26 February 2014

USYD Campus Improvement Program - SSD 6123

Precinct D - Health, Camperdown Campus in the wider USYD Campus Improvement Program - SSD 6123

01 HEALTH - SECTION 1 PROPOSED

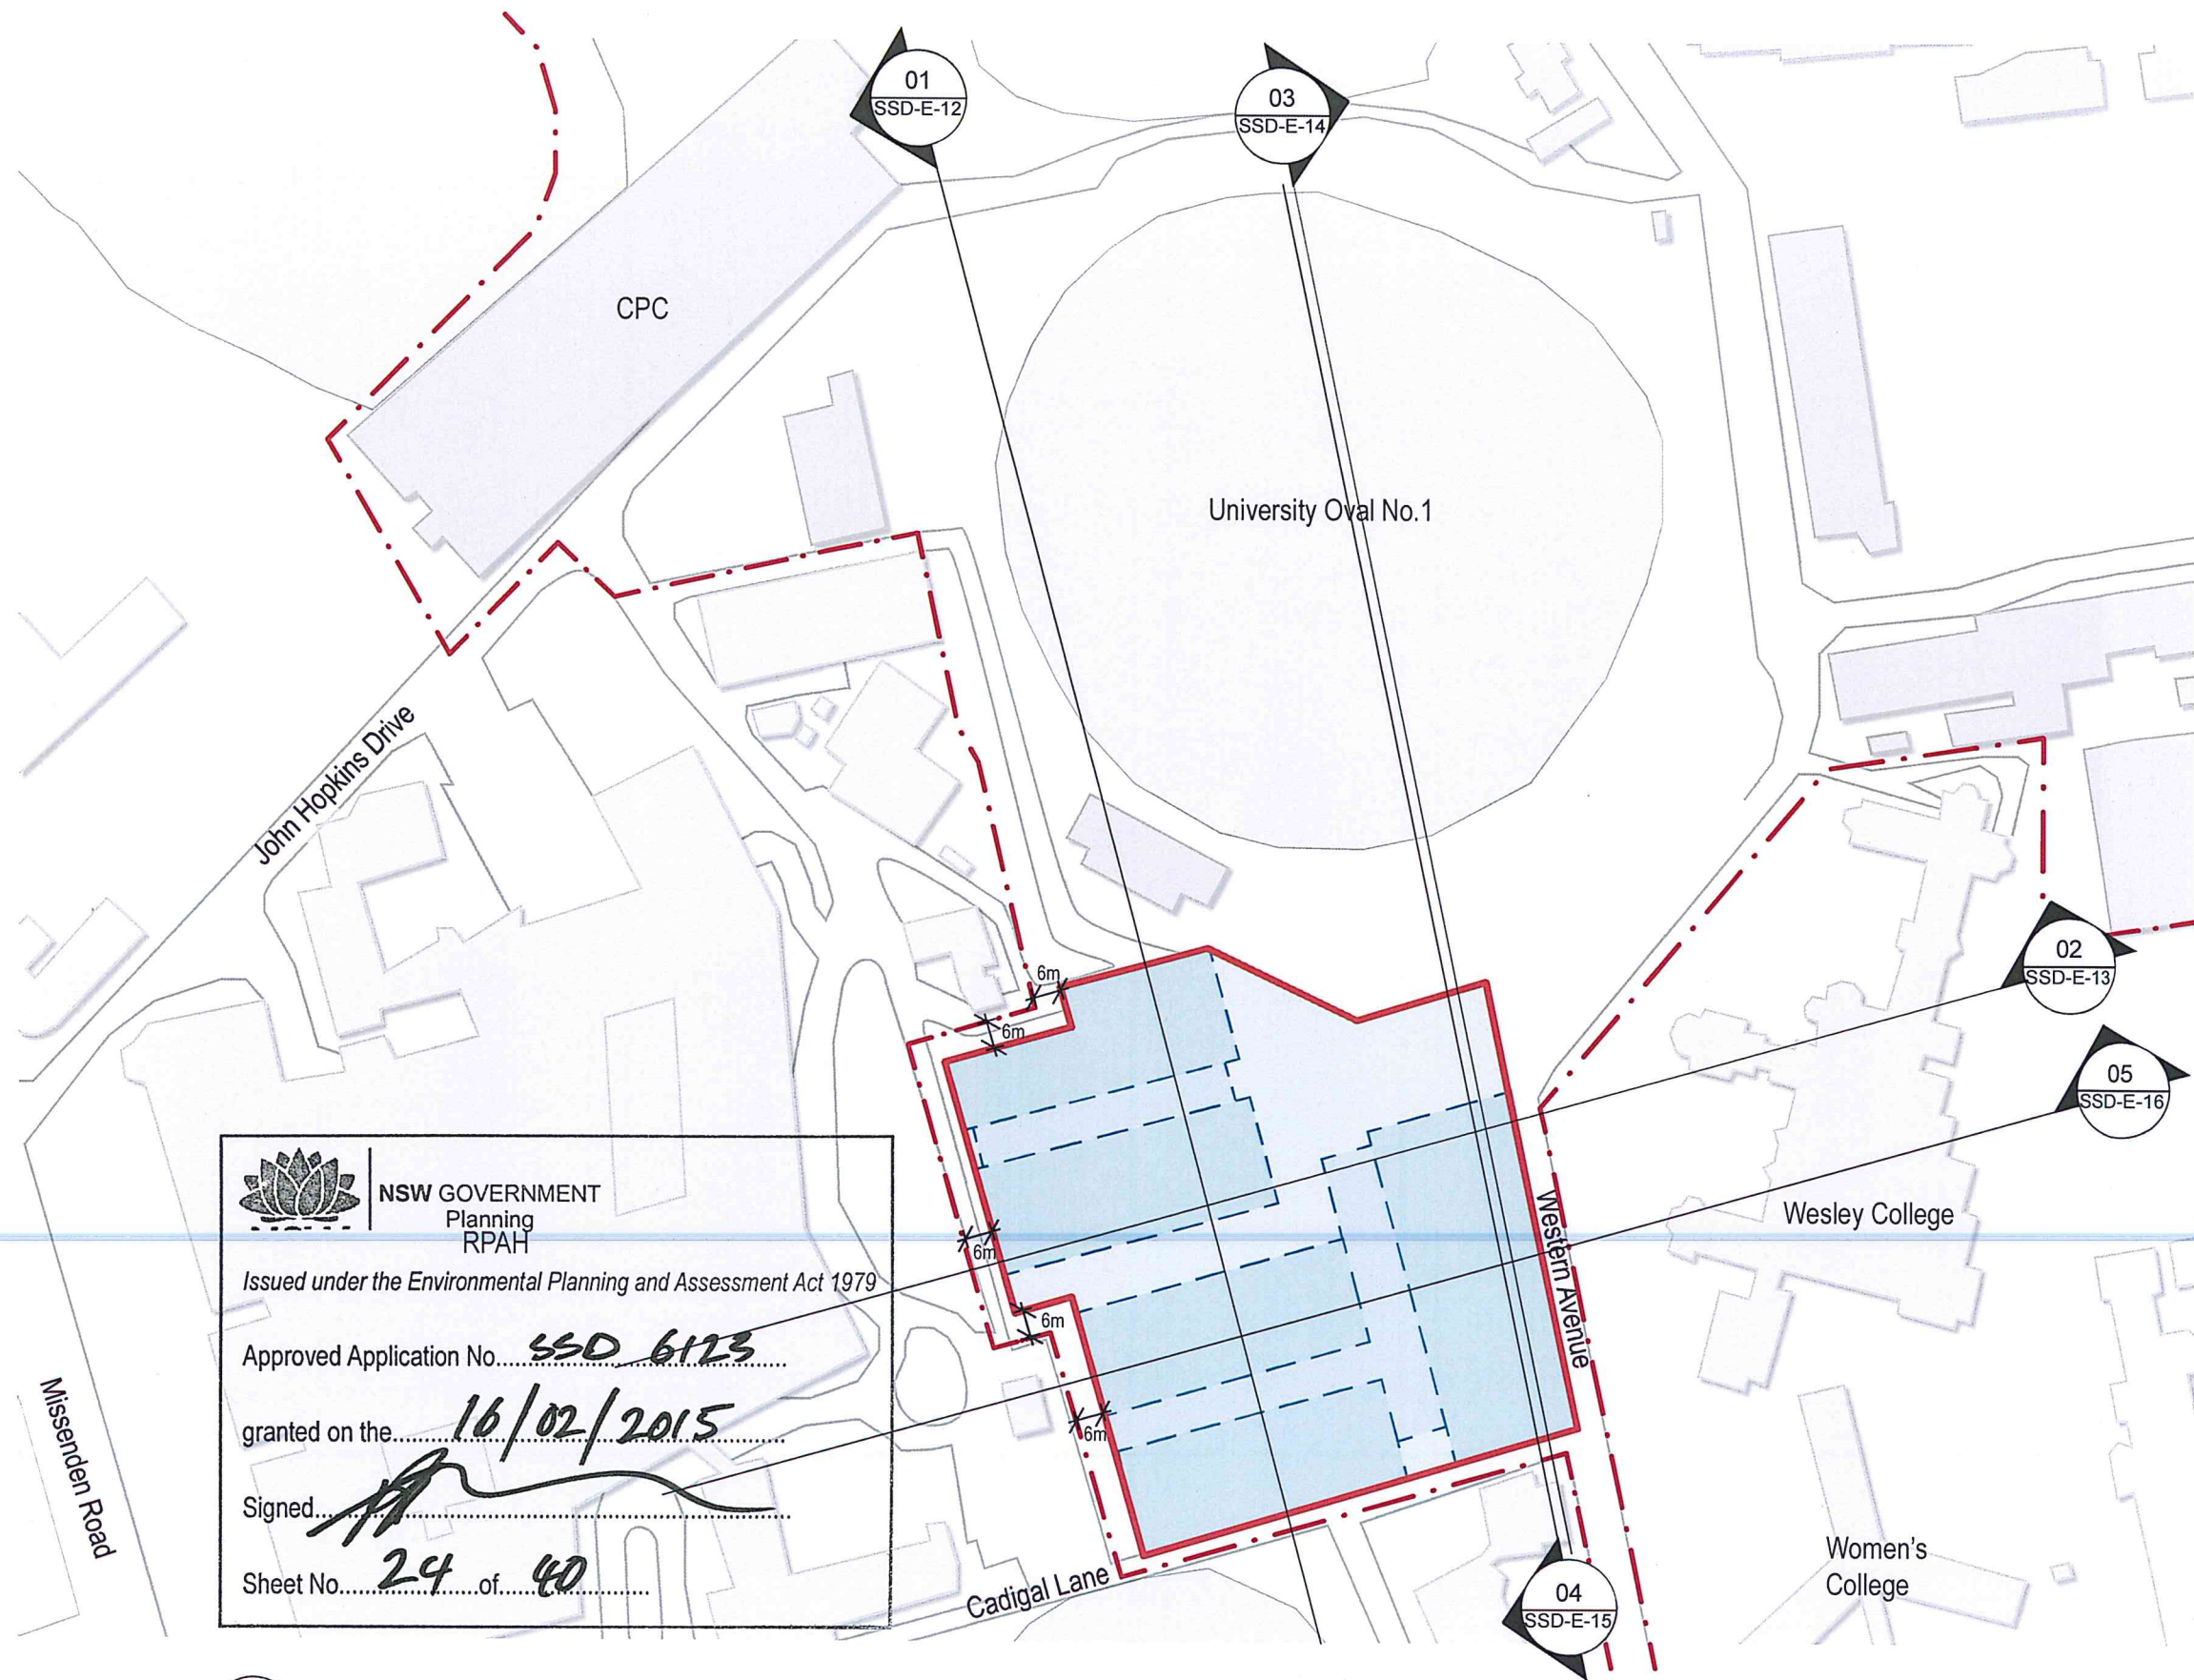
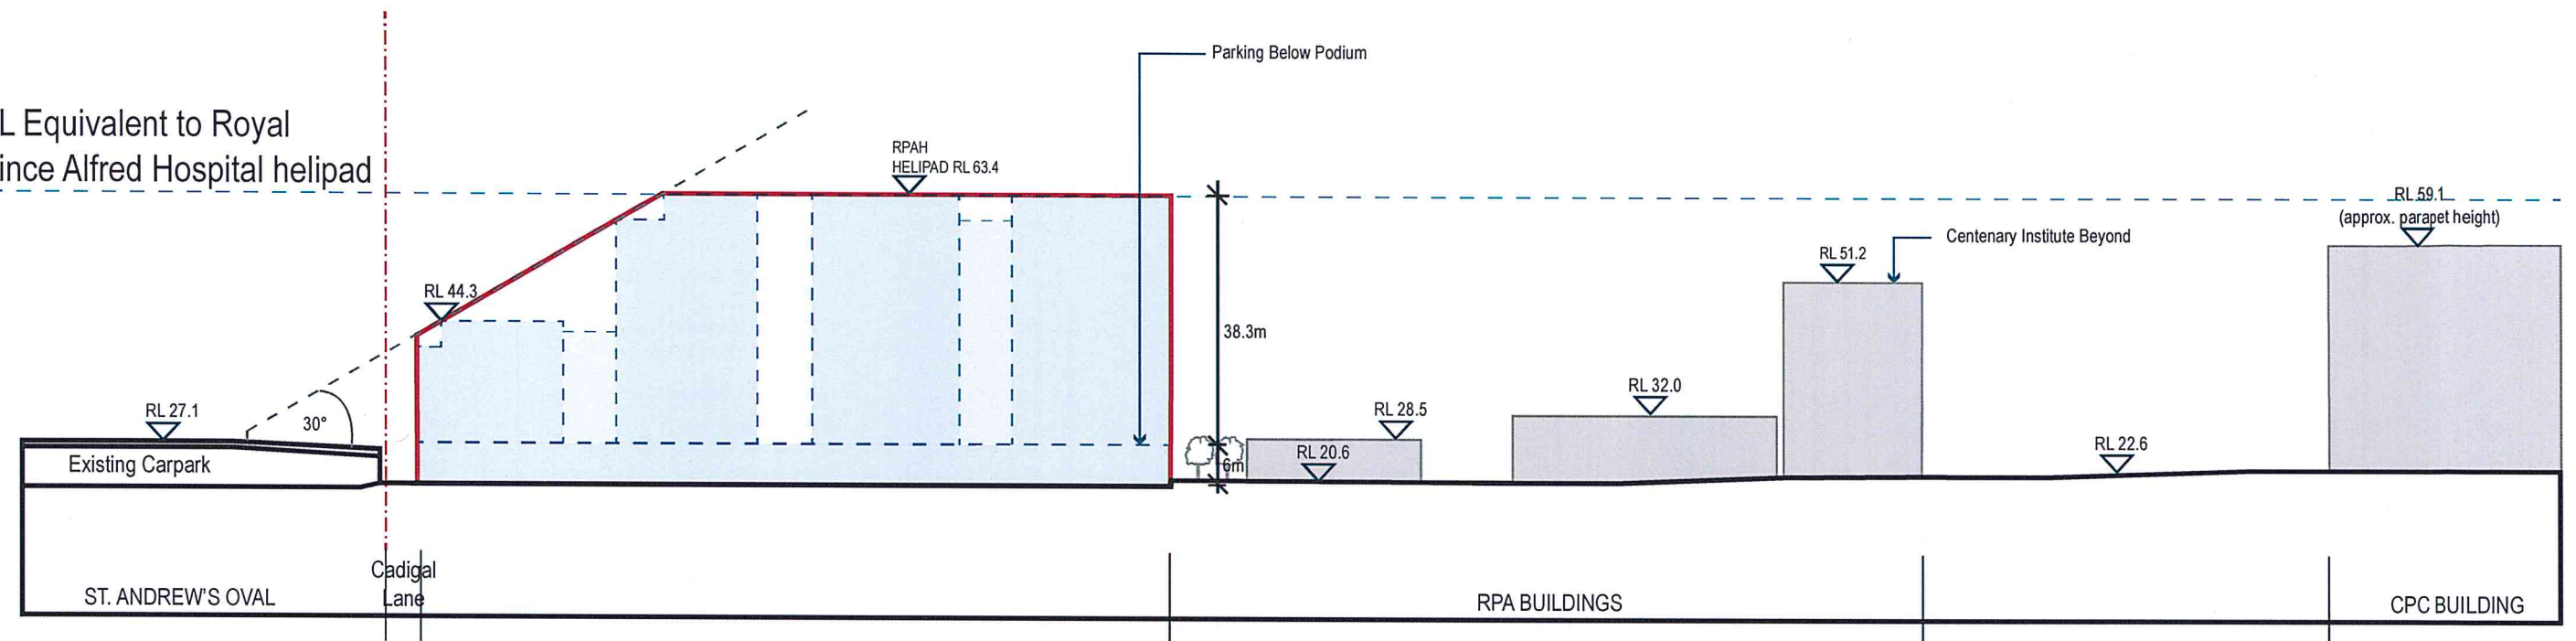
- The built form along Western Ave has no setback and appears to be 3 levels high. That is a fundamental change for the current Western Ave character in this precinct. The current buildings are residential and are basically 2 and 3 story high buildings with significant setbacks (That being St Andrews, Wesley and The Women's College).

- Only the existing Bosch Building has no setback but it is only currently 1 storey high. We believe that the overbearing height of the envelope is a bad urban design outcome, and either height must be reduced or setbacks introduced to improve the urban design result.

- We note that the Western Ave edge is described as an "active edge, which is highly desirable, but activity normally only occurs at ground level, so the best result would be retail / active at the street face level with a setback above.

- We note that the bulk of the buildings are setback into the middle of the medical precinct site, but building heights of 62M and 49M are shown presenting as blank vertical walls to Western Ave. These walls are approximately 16 stories and 13 respectively, and clearly the envelopes have been planned to soften impact on St Andrews Oval, but at the expense of a reasonable urban design outcome as it presents to Western Ave and the residential Colleges (Wesley and Women's) that look out in the westerly direction.

There needs to be significant re-working of the building envelopes to soften the impact of the building bulk as currently presented. As it stands, it will completely change the character of this low scale heritage precinct within the university.
